**KIRKLEES METROPOLITAN COUNCIL  
INVESTMENT & REGENERATION SERVICE**

**DELEGATED DECISION TO DETERMINE PLANNING APPLICATIONS**

Reference No:	<b>2023/62/92174/W</b>
Site Address:	46, Beaumont Park Road, Beaumont Park, Huddersfield, HD4 5JP
Description:	Erection of two storey side extension to north eastern elevation, construction of canopy to south eastern and south western elevations and associated alterations
Recommending Officer:	Tom Hunt

## HOUSEHOLDER DELEGATED REPORT

PROJECT TITLE Proposed Side Extensions, Canopy & Alterations	CLIENT Tom Ward 46 Beaumont Park Road, Huddersfield
DRAWING STAGE Planning	SCALE 1:50, 1:100 @ A1
SHEET TITLE Plans and Elevations as Proposed	PROJECT NUMBER HD4-3574
CHK SWG	DRAWN BY CS
REV B	SHT 002

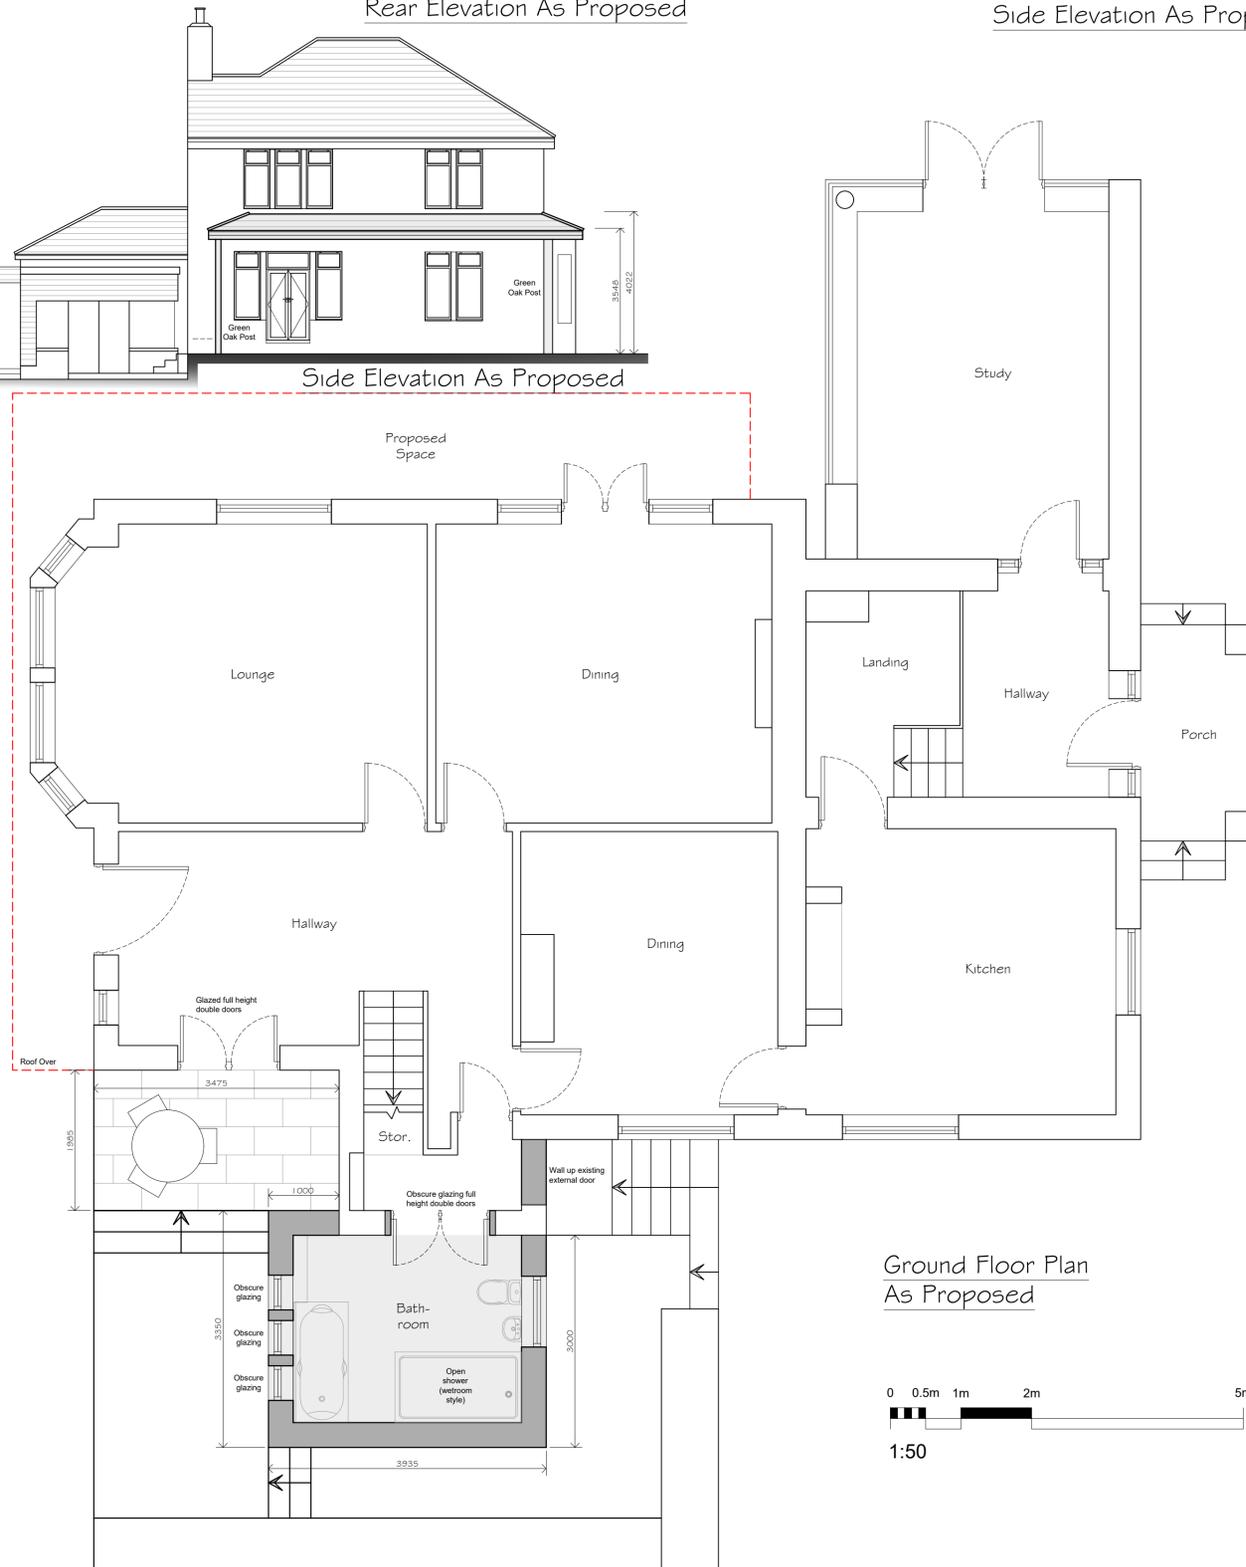
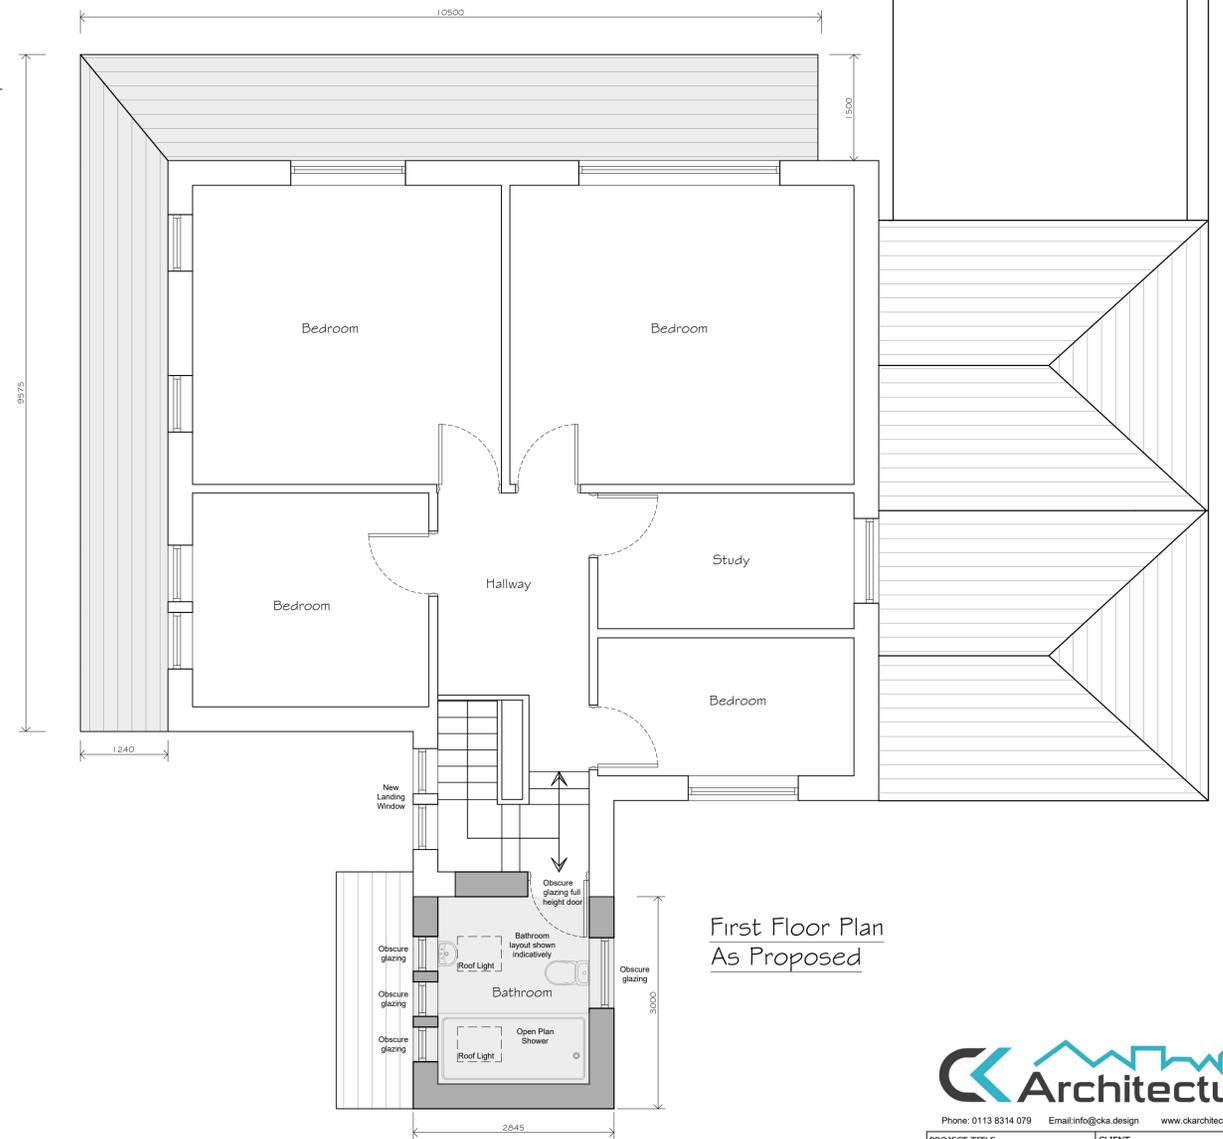
Pitch roofed with roof lights over two storeys, with small single-storey projection a ground with lean-to roof:

- ~7.5m roof ridge height & ~6.2m eaves height from ground at two storeys
- ~4m roof ridge height & ~3.5m eaves height from ground at single-storey
- ~3m projection from side at both storeys
- ~3.9m depth at ground; ~2.8m depth at first floor

*Officer Note:* Plans show height from hardsurface hence the modest variation from annotated plans to description.

Windows front and rear (all obscure glazed apart from rear elevation ground floor window). Clad in natural stone with dark slate tile to match host.

- ~4m ridge height x ~3.5m height from ground
- Projecting a range of 1.15-1.5m from the elevation

Roofed in dark slate tile. Green Oak posts.

Conversion of ground floor Window to patio door on northeast elevation.  
 Addition of first storey window to original side projection

<b>Two storey side extensions should:</b>	<b><u>Yes - COMPLY</u></b>	<b><u>No - JUSTIFY</u></b>
Not take up all or most of the space to the side of a house	Yes – extremely limited depth and width with adequate separation distance to flank boundary	
maintain a 1 metre gap to the side boundary to ensure the building is not too close to a neighbouring property	Yes	
be set back at least 500mm from the front wall of the house	Yes

<b>the Kirklees Local Plan and the NPPF</b>		
Impact on the Local character and street scene	<ul style="list-style-type: none"> <li>• KDP1 of the SPD</li> <li>• Policy LP24 Design (a) and (c) of the KLP</li> <li>• Chapter 12 NPPF</li> </ul>	Minimal, property is well set back from the highway on both front and rear elevations. Use of natural stone and slate material will harmonise the extension and alterations with the streetscene.	✓
Impact on original house	<ul style="list-style-type: none"> <li>• KDP2 of the SPD</li> <li>• Policy LP24 Design (c) and (d) of the KLP</li> <li>• Chapter 12 of the NPPF</li> </ul>	Building has had a series of organic extensions over time mainly restricted to single-storey; the original character and design of host is asymmetric so the extension would be regarded as a modest continuation of this. The roof canopy would alter the front elevation to change its original character and appearance moderately however the alterations would be seen in the context of the extended host, be permeable showing the original elevations and therefore not be regarded as a detrimental addition. The matching materials and fenestration aid in a harmonised appearance. Acceptable.	✓

Impact on privacy of neighbours (to sides, rear and front)	<ul style="list-style-type: none"> <li>• KDP 3 &amp; 4 of the SPD</li> <li>• Policy LP24 Design (d) (iv)</li> <li>• Chapter 12 of the NPPF</li> </ul>	The new fenestration within the extension and to first floor of the side projection at the front faces open space. The addition rear elevation windows has substantial separation distances (in excess of the minimum recommended 21m within para. 4.10 of the SPD) to properties north avoiding any overlooking/loss of privacy. The converted window to patio door to side elevation at ground floor would not markedly change the existing relationship between northeast neighbour no. 27 (this is forward of the side elevation patio doors).	✓
Impact on light and outlook of neighbours (to sides, rear and front)	<ul style="list-style-type: none"> <li>• KDP 4, 5, 6 of the SPD</li> <li>• Policy LP24 Design (b)</li> <li>• Chapter 12 of the NPPF</li> </ul>	The extension would be to the southwest of No. 27 with a modest increase in bulk and massing over the existing arrangement. Separated sufficiently from its southeast facing elevation windows to ensure adequate 45° field of outlook. No additional significant impacts.	✓
